Formation of balcony over rear elevation flat roof extension (approved under
LU/116/19/PDH)

62 Parkside Avenue Littlehampton

Re: planning application reference LU/290/19/HH.

PROP. ELEVATIONS

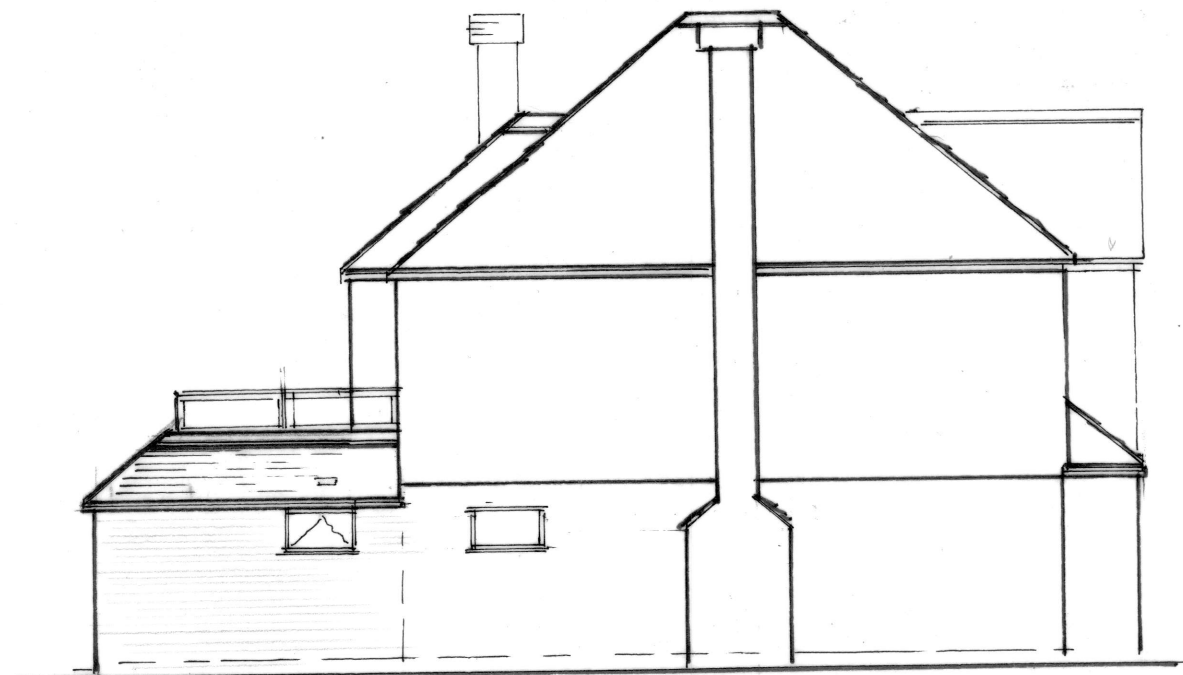
Specifically, we feel that such a facility would constitute excessive intrusion into the privacy of our house and garden where we spend a great deal of time. (You are welcome to visit to see the results.) We would potentially be under the gaze of onlookers with an elevated view into our garden making us feel ill at ease. Further, and perhaps a cause for greater concern, visual access into our bedroom would be possible from this balcony.

One of the material considerations in your guidance is the effect on privacy of an existing property. In our opinion the effect of the proposed balcony would compromise our privacy.
